Address: 97 Tunnacliffe Road Huddersfield HD4 6QJ

Application number: 2024/93457	
What is the application for?:	Erection of first floor side and front extension and alterations and change of u
Address of the site or building:	95, Tunnacliffe Road, Newsome, Huddersfield, HD4 6QJ
Postcode:	HD4 6QJ

Drawing
Proposed Elevations

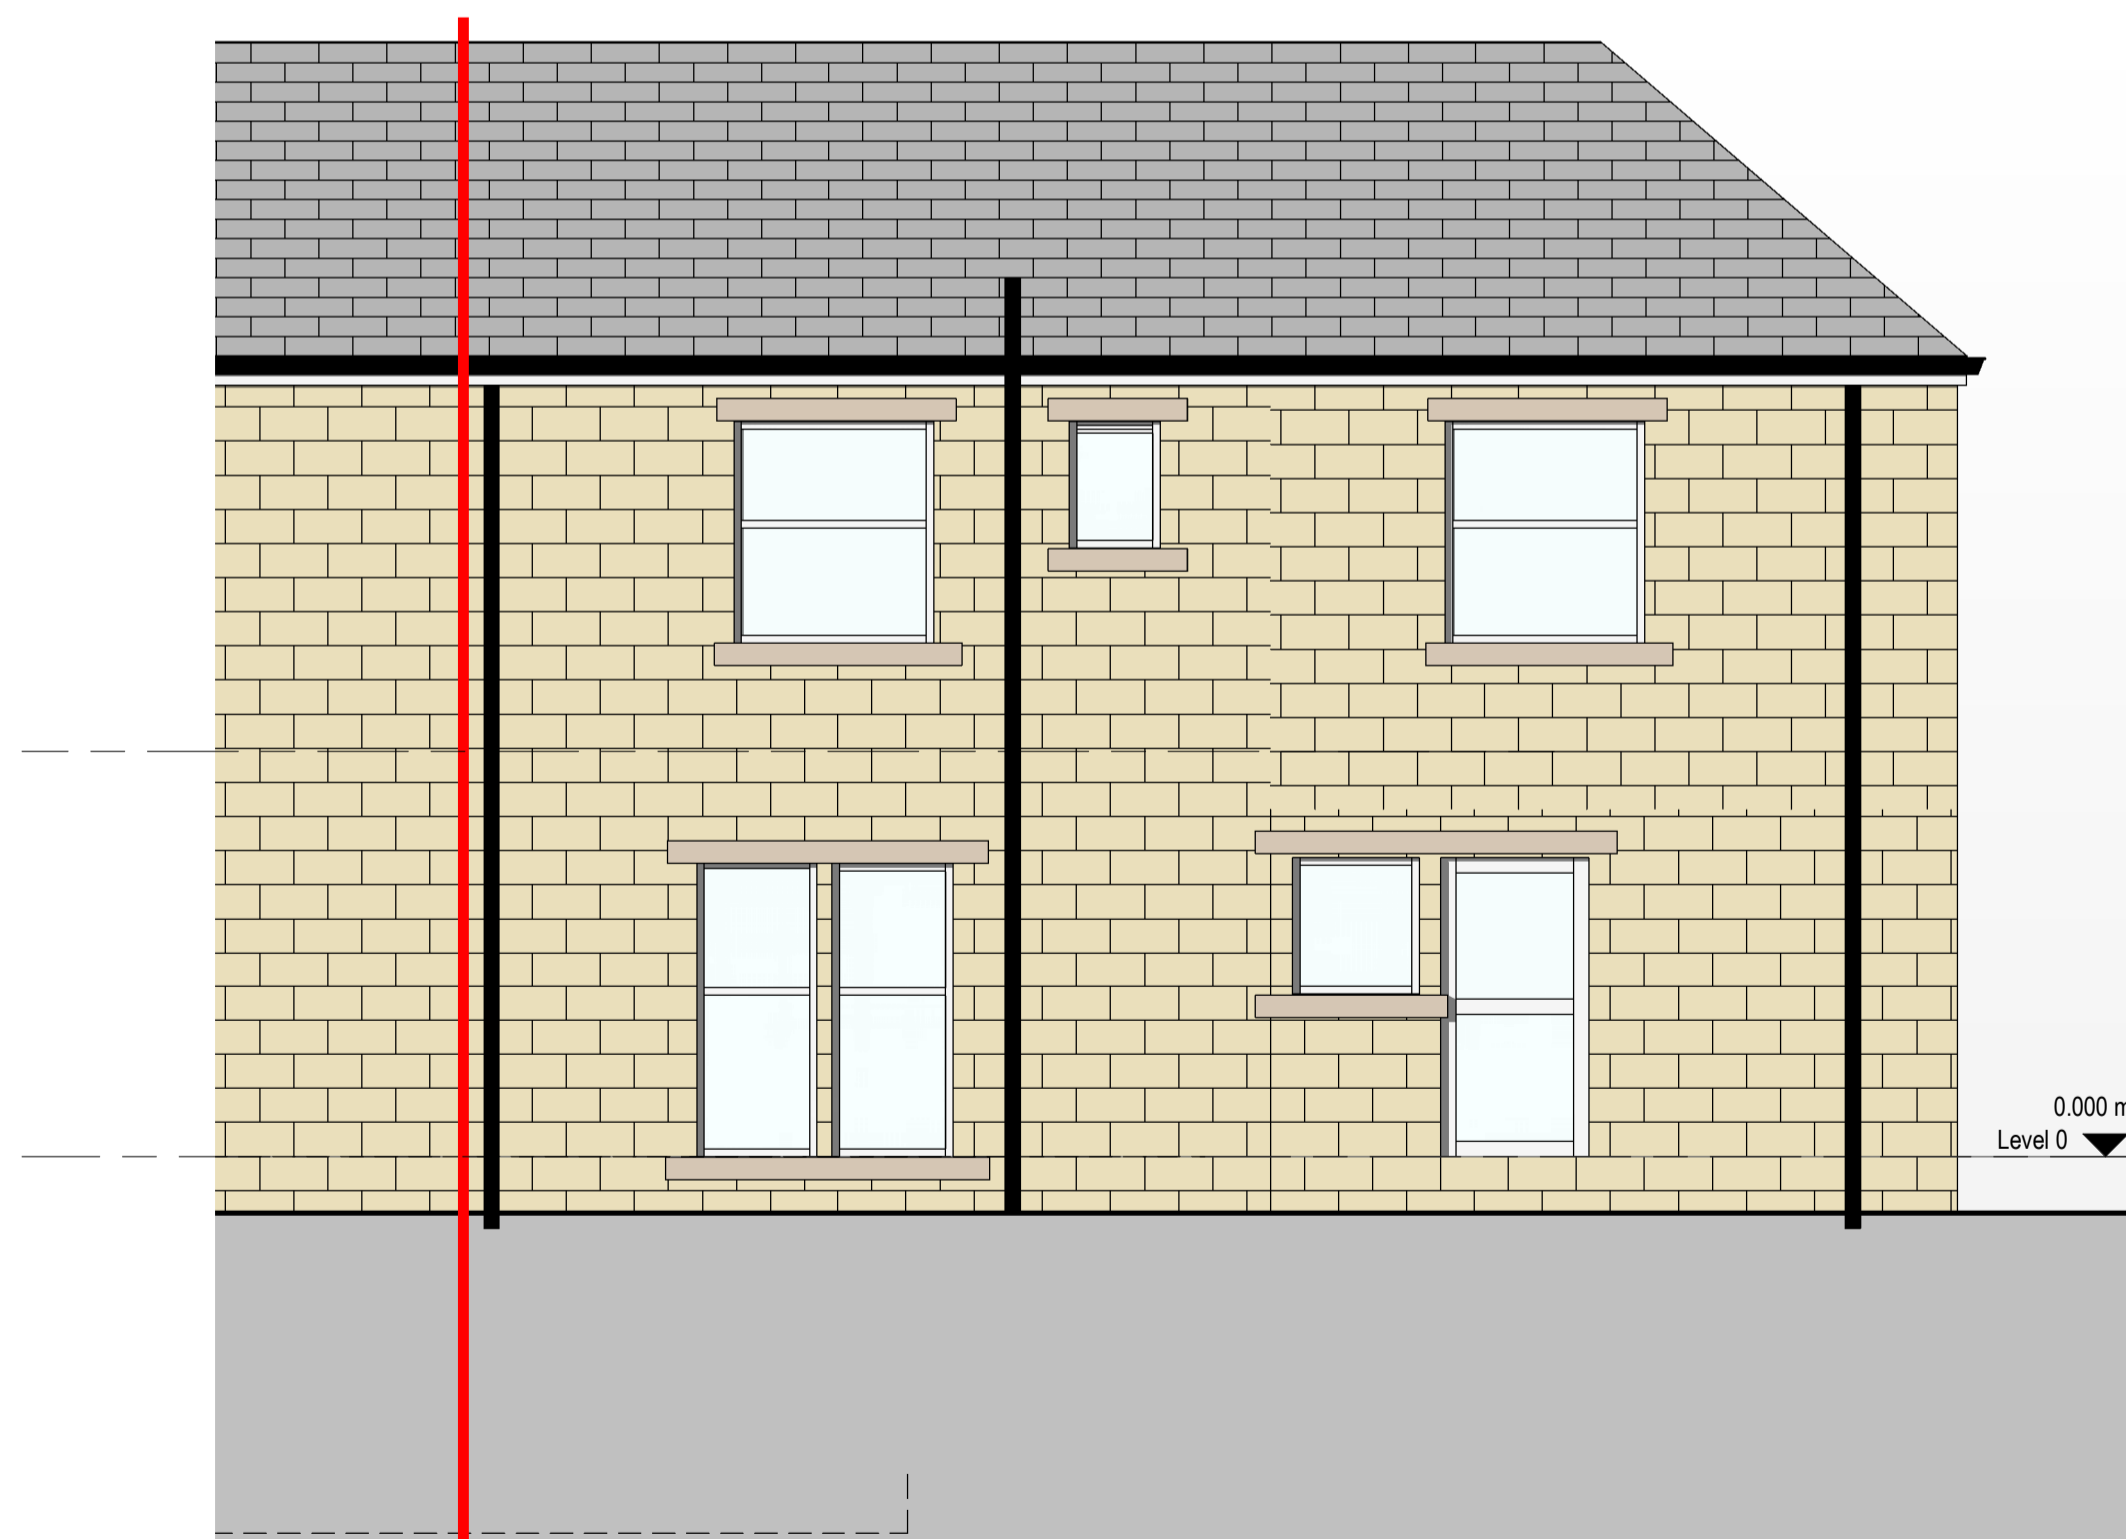
Type of comment: An objection	
Do you wish your comments to be published on the website anonymously?	No
<p>1. Community Safety Concerns</p> <p>Since its acquisition in November 2023, the property has been used to care for young vulnerable adults with communication difficulties. Unfortunately, this has resulted in a significant increase in disruptions and ongoing crime within our neighbourhood, including:</p> <p>Theft of items such as garden washing, bicycles, and a mobility scooter. Break-ins at garages to the rear of the property for storing stolen goods. Regular police presence due to various disturbances, including a concerning incident involving a vulnerable adult wielding a knife. On multiple occasions we have been required to intervene and support the staff of 95 Tunnacliffe Road with the challenging behaviors of two of the young vulnerable adults in their care. These incidents have caused considerable distress to residents, including myself, my partner, and other families on Tunnacliffe Road. Expanding the property to accommodate additional tenants could exacerbate these issues, further endangering community safety.</p> <p>2. Parking and Traffic Issues</p> <p>The property lacks dedicated parking facilities, and the road is already congested. Additional tenants and staff would intensify the parking pressures, creating further inconvenience for residents. Increased traffic from staff and tenants could elevate risks on this residential road.</p> <p>3. Waste Management Challenges</p> <p>The proposed increase in occupancy will generate more waste. The limited storage area at the front of the property is inadequate for larger bins or commercial waste solutions such as a Biffa bin. This could lead to unsightly and unhygienic conditions.</p> <p>4. Extension and Construction Concerns</p> <p>The proposed extension would have a direct and negative impact on our property: It would obstruct a ventilation grill for my bathroom. The extension would attach to the front of my property for approximately 1 meter. Please see attached photo (Blue marks the edge of our property and red marks the edge of the proposed extension). It would block natural light into the same bathroom and the window would open directly</p>

it would block natural light into the same bathroom and the window would open directly into the view of the wall on the proposed extension.
